DRB Application No.: 06DRB-00804 (SBP)

Project Name DR SHAWN HWANG DENTAL

TO: Sheran Matson, DRB Chair
FROM: Stephanie Shumsky, Planner, Maggie Gould, Associate Planner
SUBJECT: Project # 1004821

The Environmental Planning Commission approved Project # 1004821/06EPC 00472, A Site Development Plan for Building Permit for an approximately 1 acre site on Golf Course Road NW Between Paseo del Norte NW and Shelly Rose Road NW, on May 18, 2006. The applicant has satisfied all of the conditions of approval with the following exceptions:
5. Applicant shall provide access agreement to show legal access to the private street prior to DRB sign off.

SHEET NO.
C-1
DRB

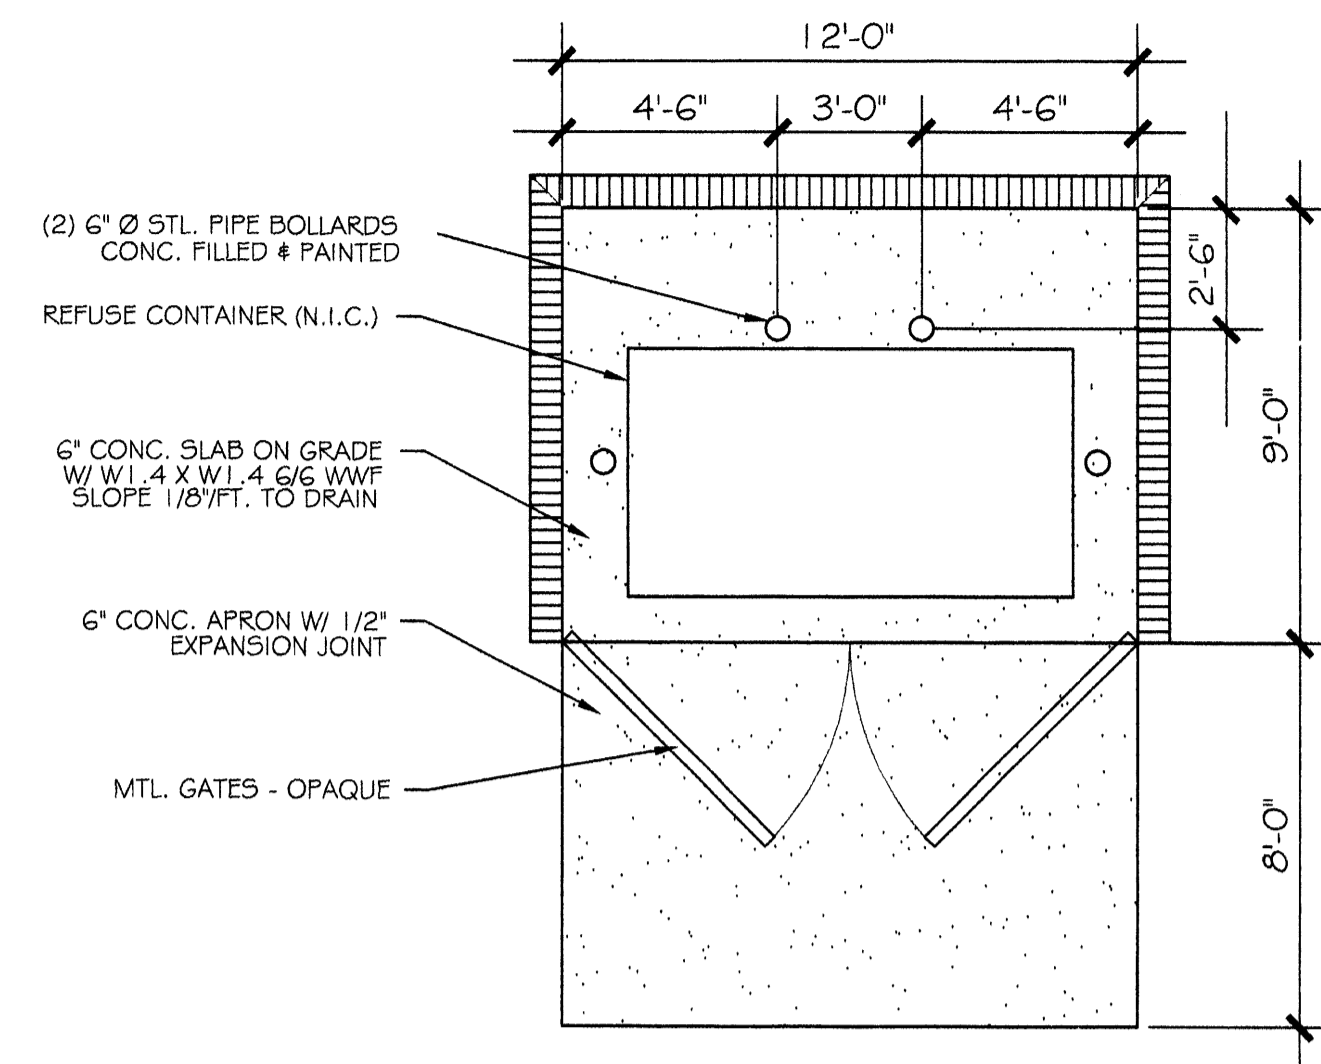
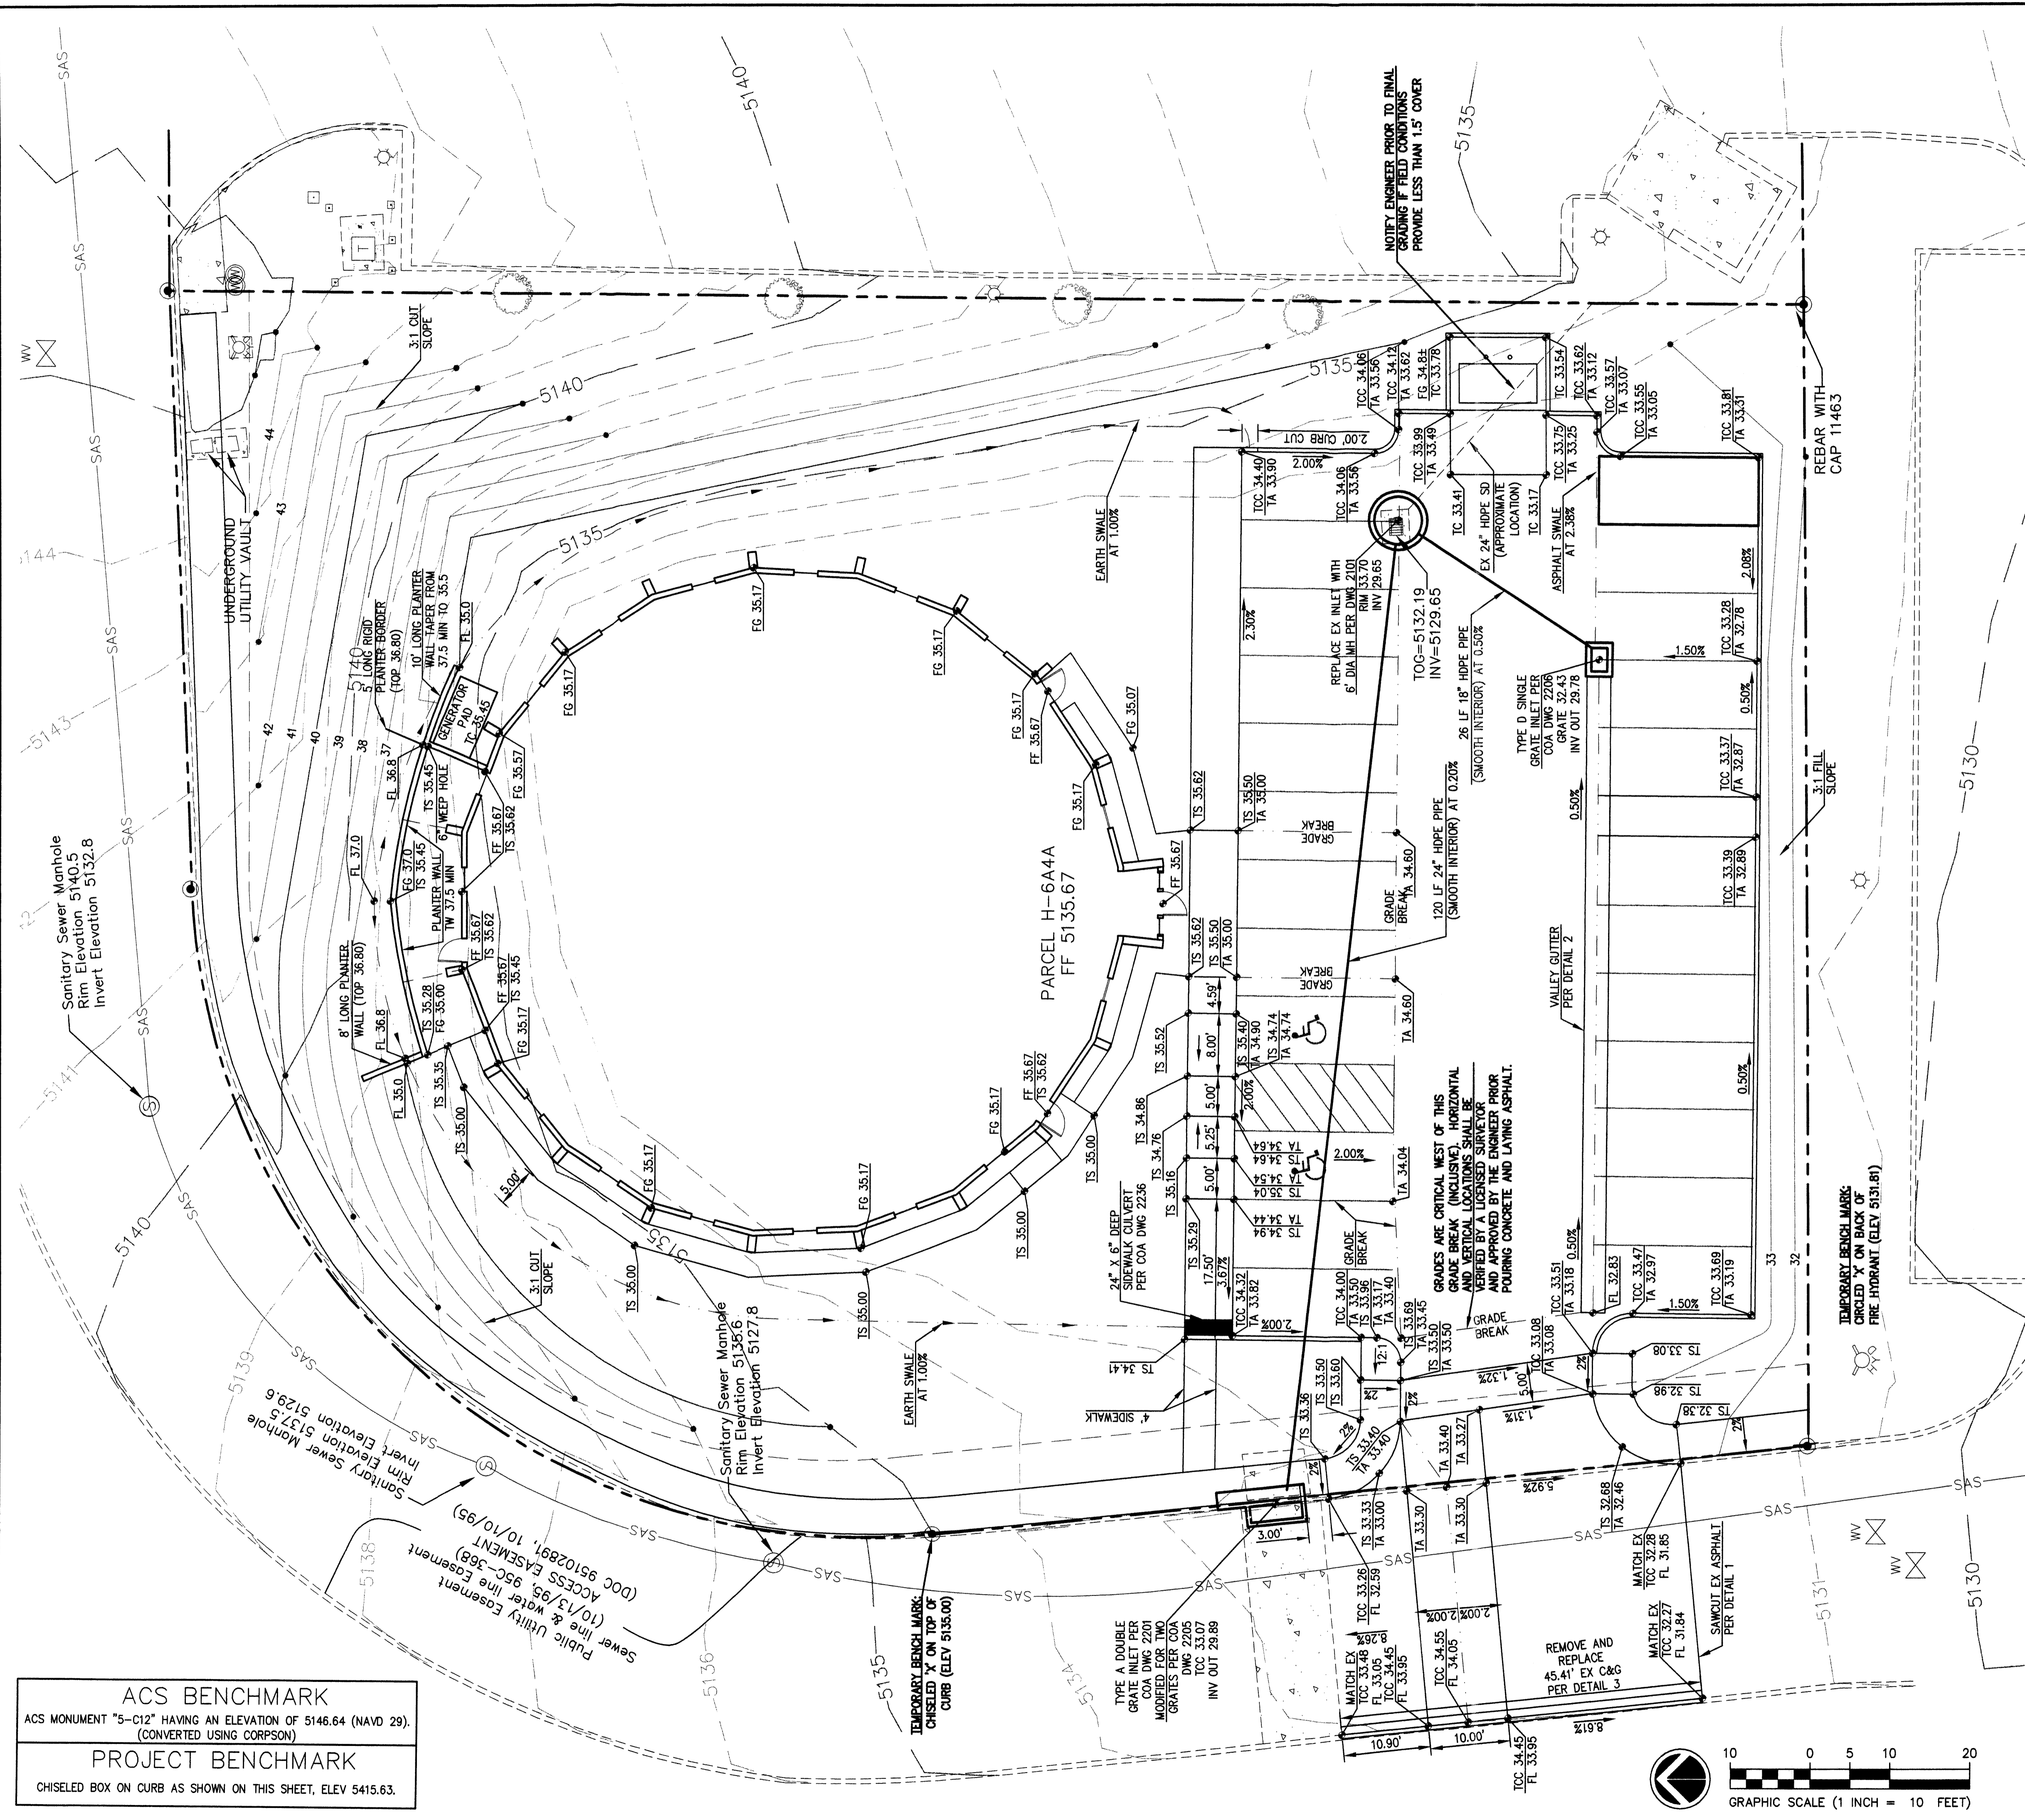
- TRANSPORTATION: X COPY of ACCESS DOCUMENT
- X ADA RAMPs w/ ADA ELEMENT
- X ADA RAMP DETAILS

SHEET NO.
C-3

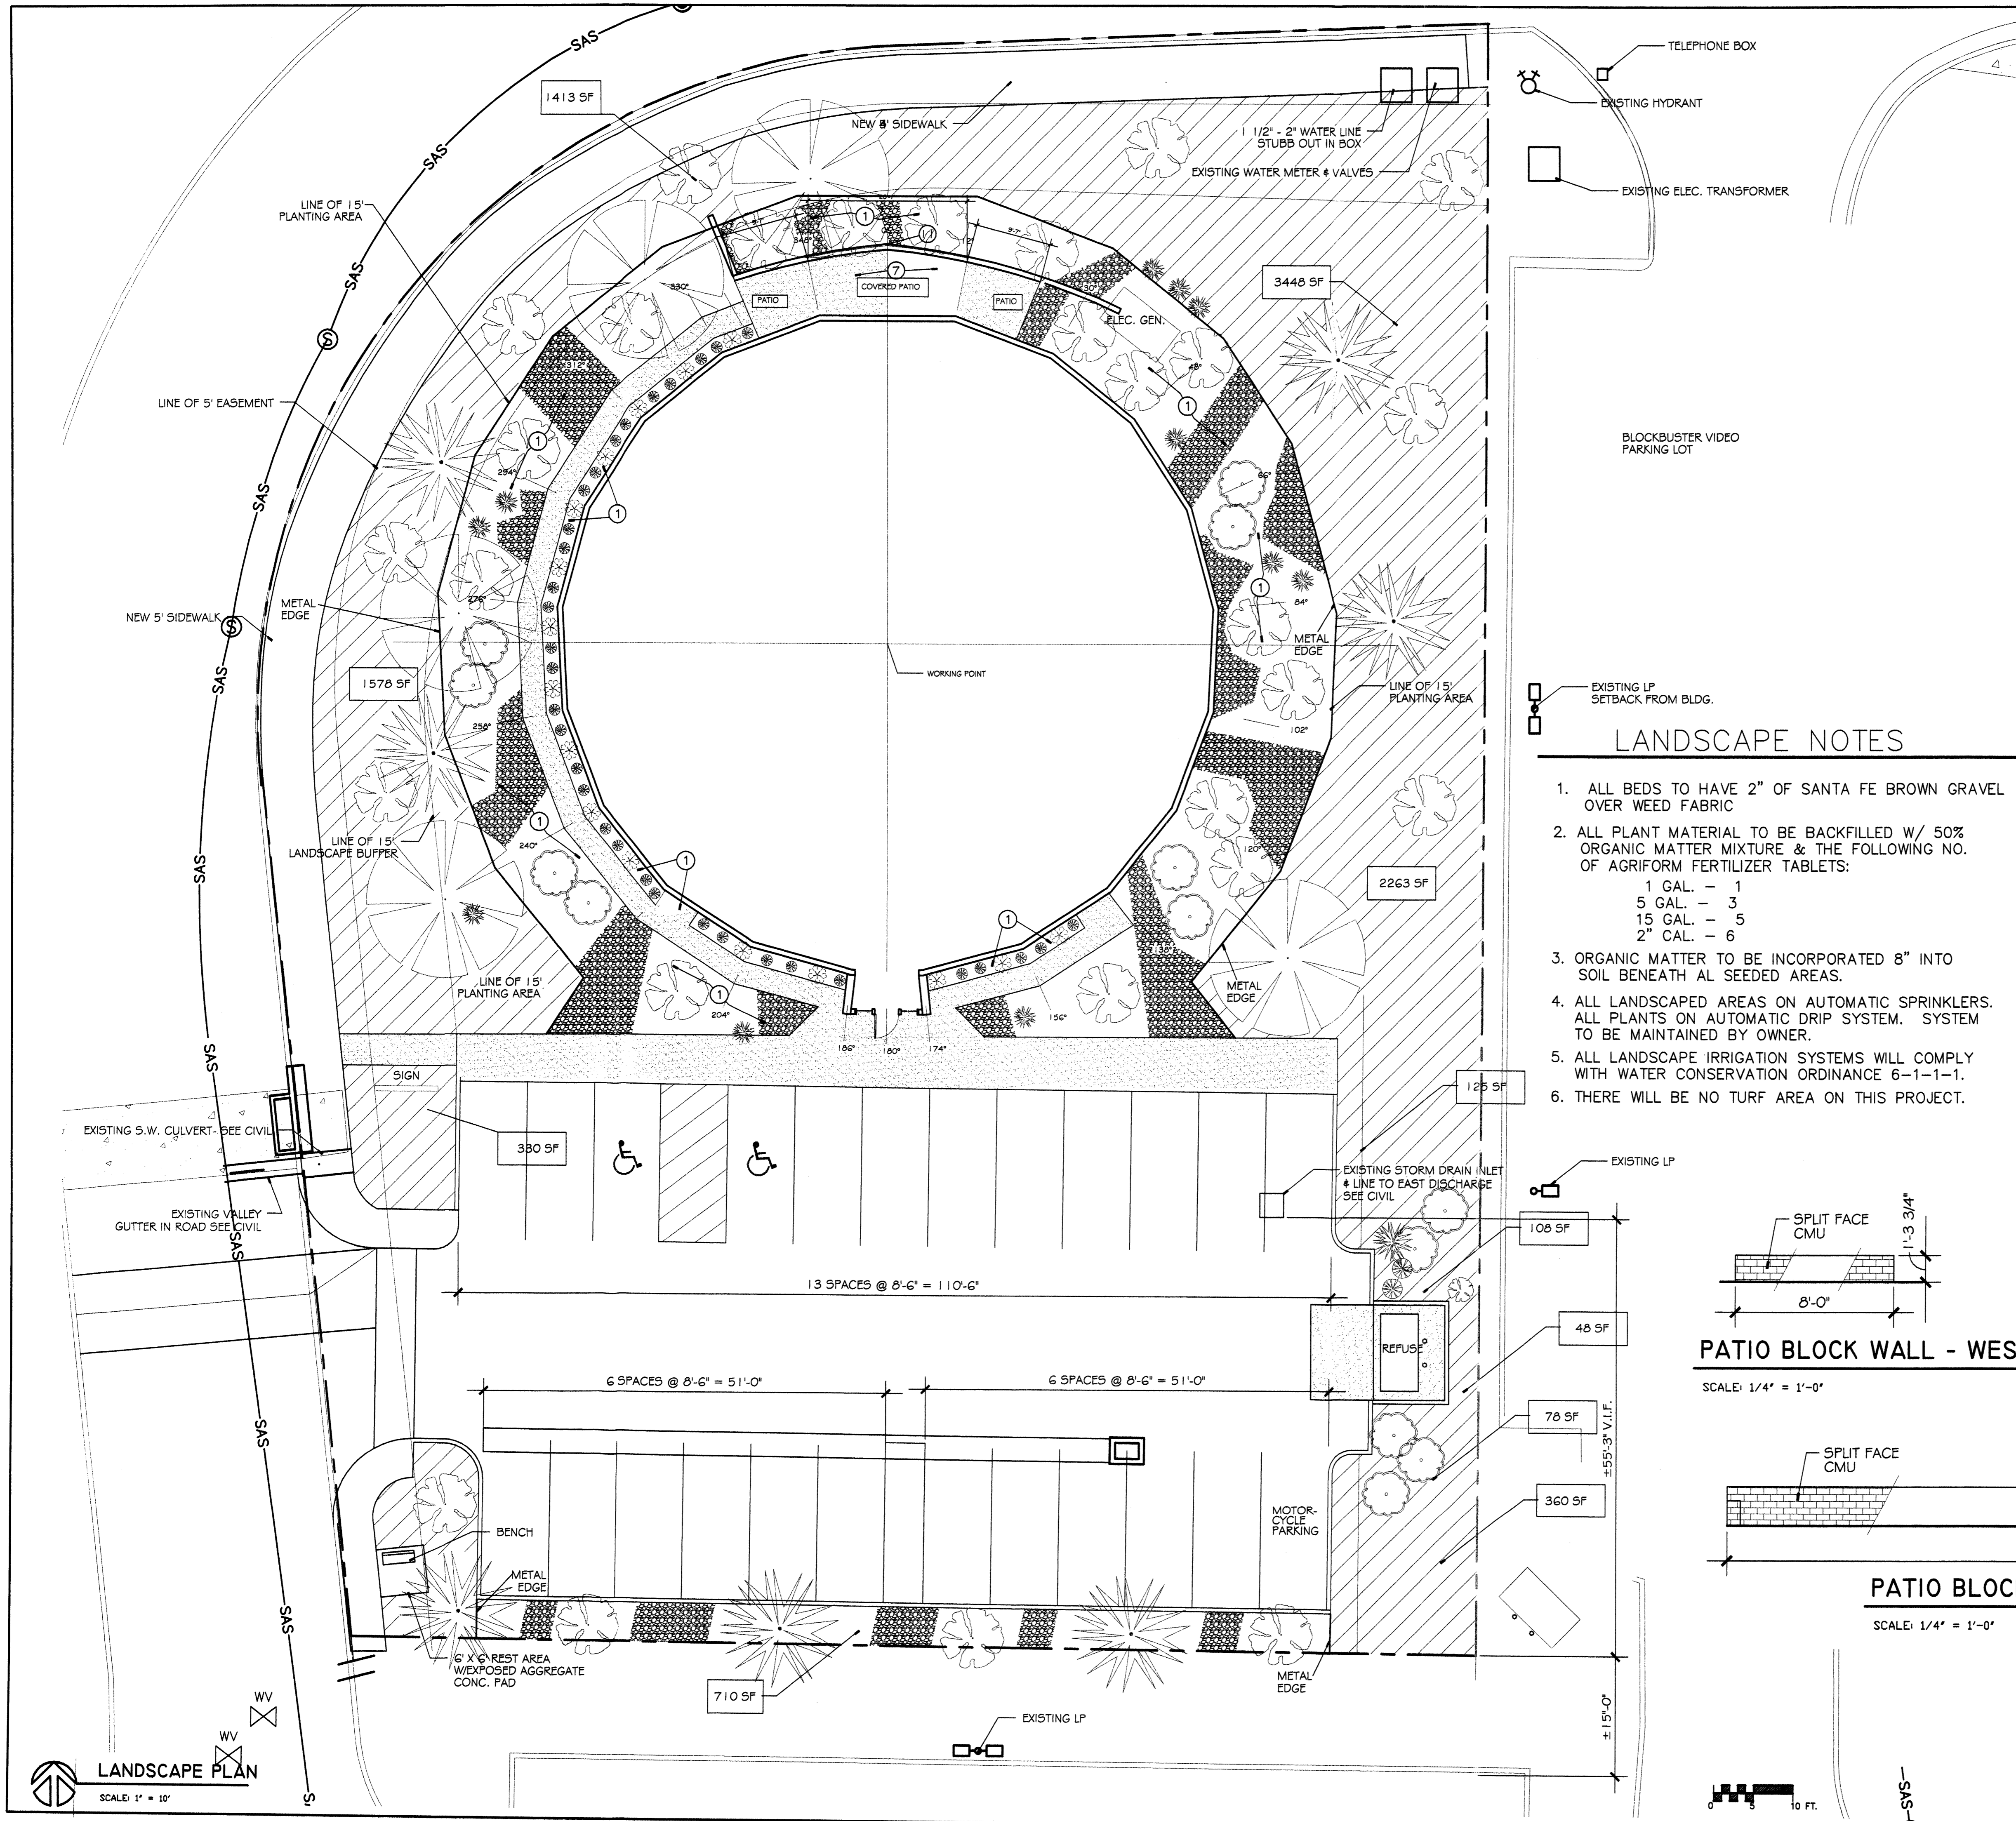
The easement is not noted on sheet C-3, as stated in the applicant's letter. Vehicular access is not clear.
